ADJOINING OWNER'S REPORT
NoDa HERRIN TOWERS
REZONING
FOR PUBLIC HEARING
PETITION NO. 2004-42
Monday January 26, 2004
Revised: March 18, 2004
REVISED ZONING CHANGE
FROM: Industrial 1 & 2, 11 & 12
TO: MUDD-O (Mixed Use Development District - Optional)

CHARLOTTE-MECKLENBURG PLANNING COMMISSION INTER-OFFICE COMMUNICATION

DATE: February 28, 2008
TO: Gary Huss, Zoning Supervisor
FROM: Debra Campbell, Planning Director

SUBJECT: Administrative Approval for Petition No. 2007-062 by Bontera Builders.
Attached are revised plans for the above rezoning petition. The plans have been revised to convert the existing commercial structure lot building "2" to a residential lot type "A".

TECHNICAL DATA SHEET

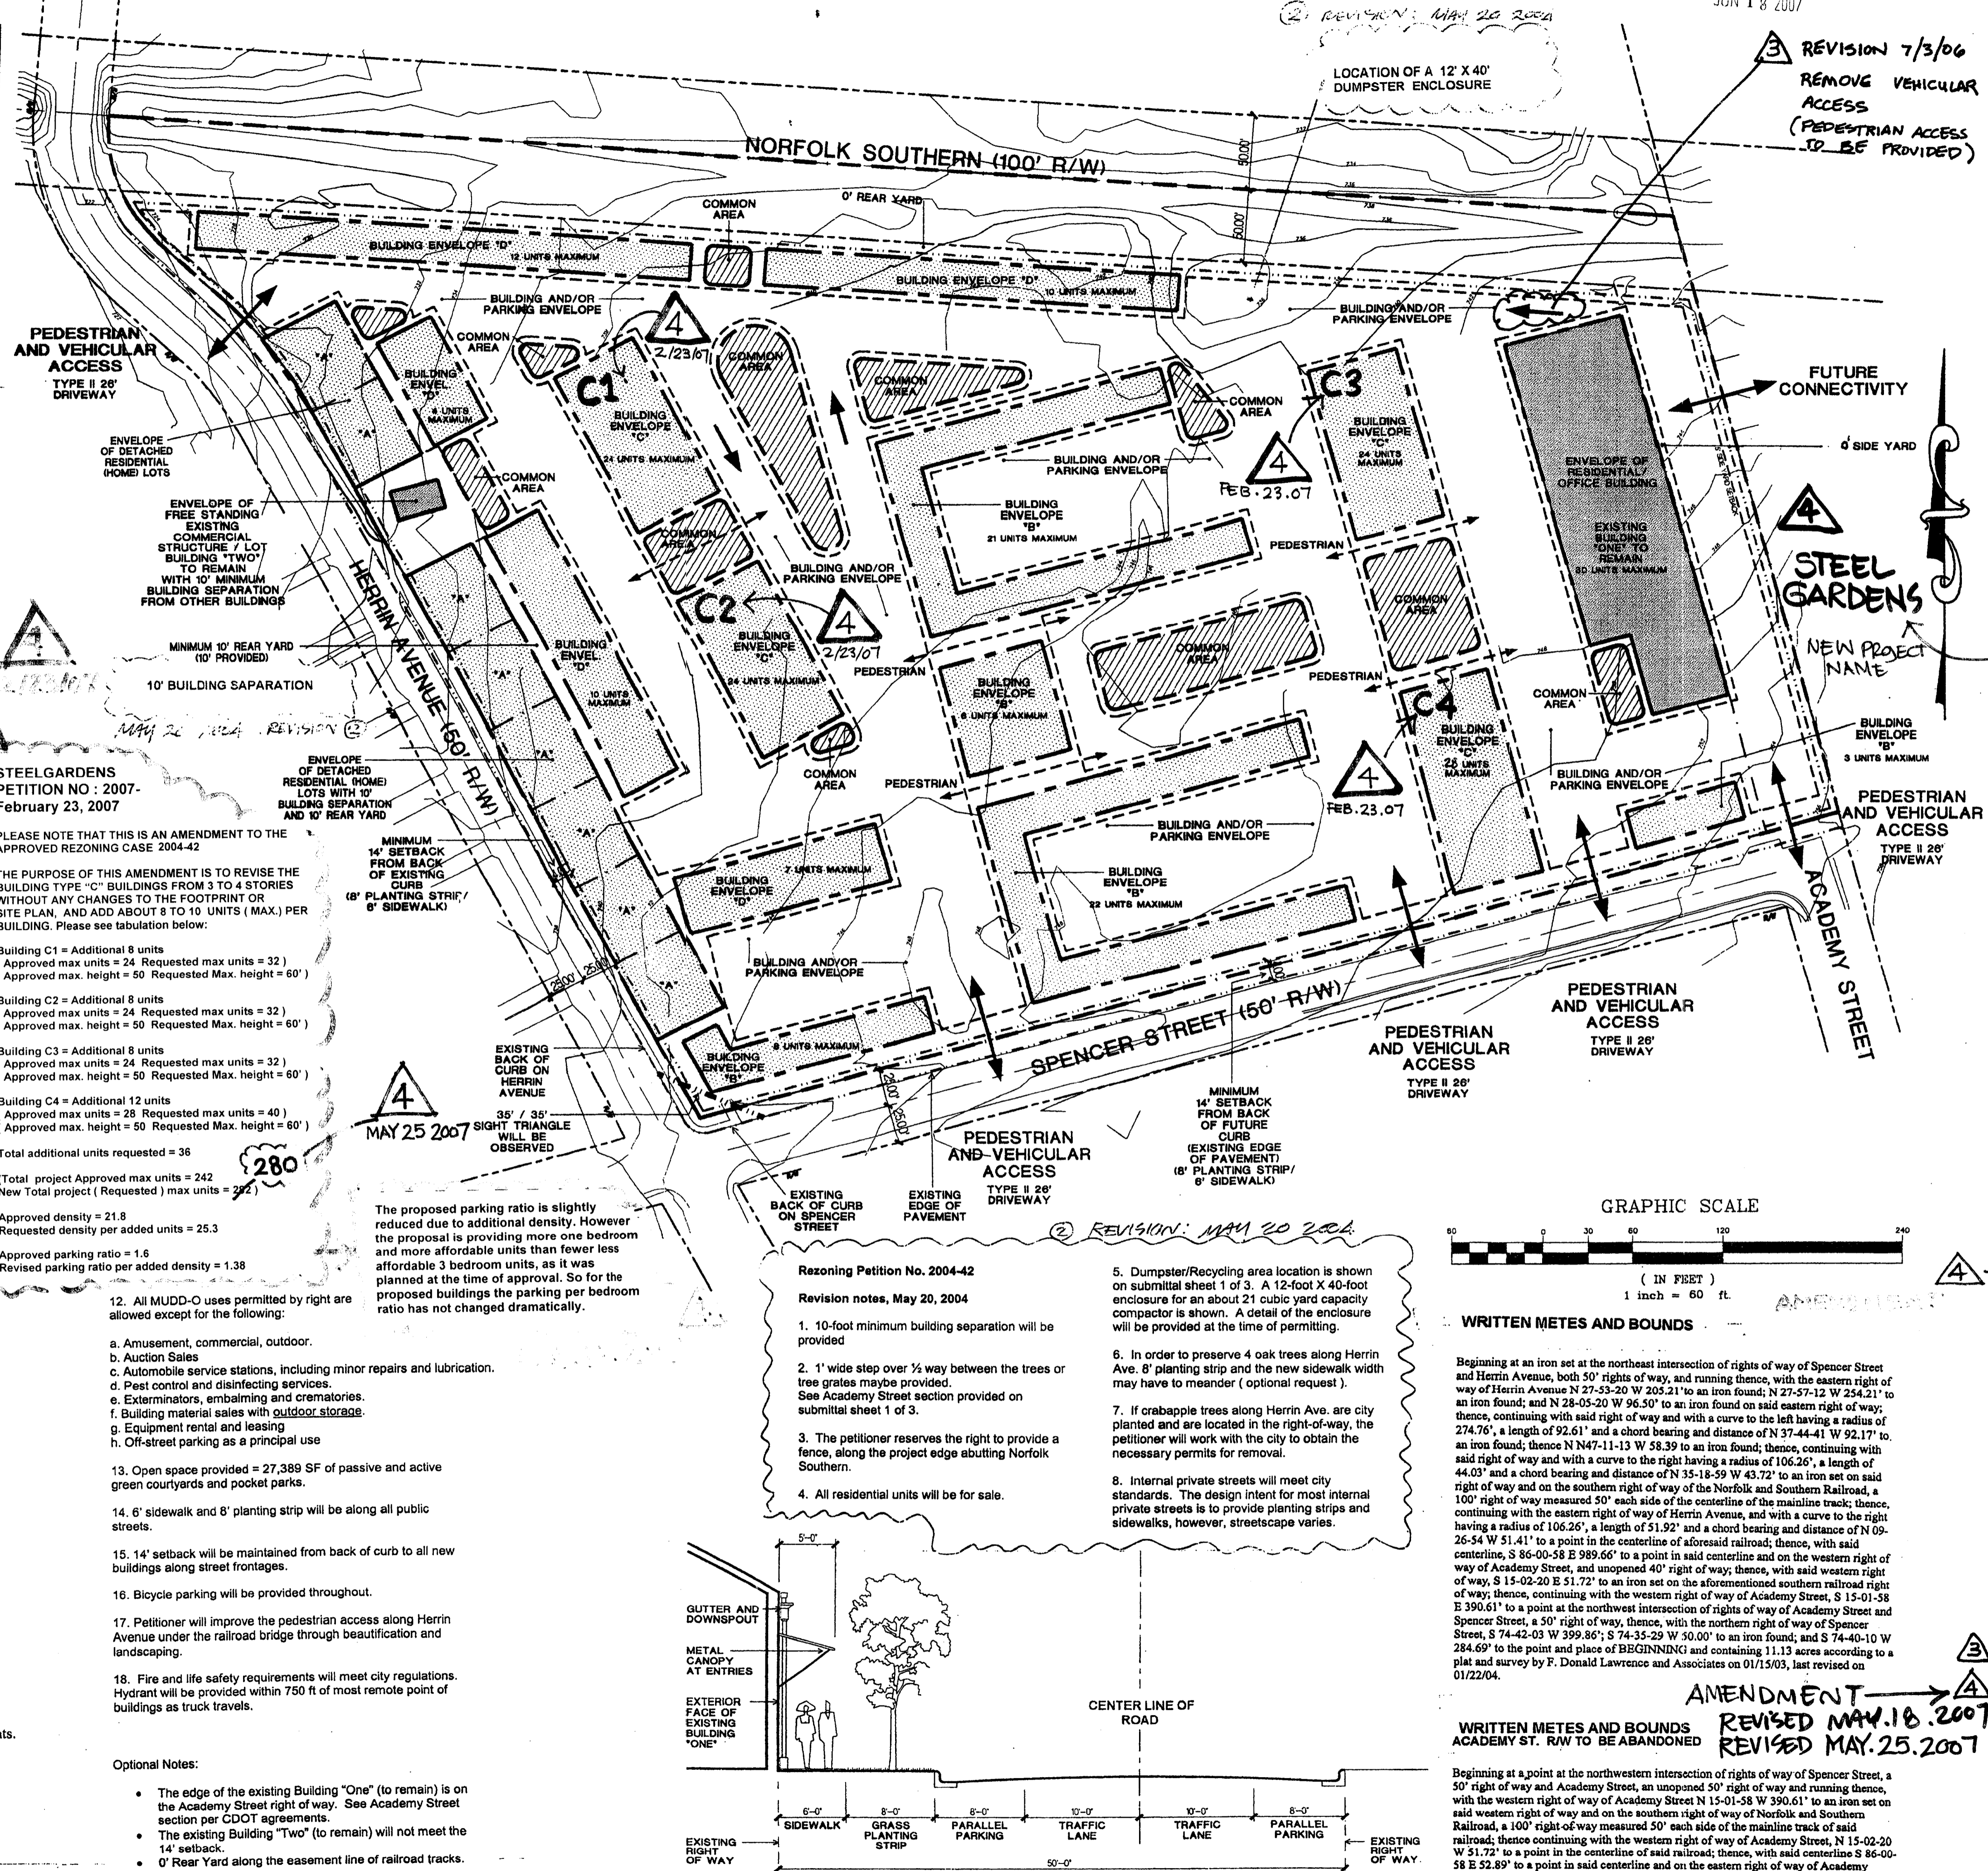
SECTION AT ACADEMY STREET
REVISION 5 February 20, 2008 = Existing building Two facing Herrin Ave. with 600 sf of commercial use to be become a single family residential lot type "A".
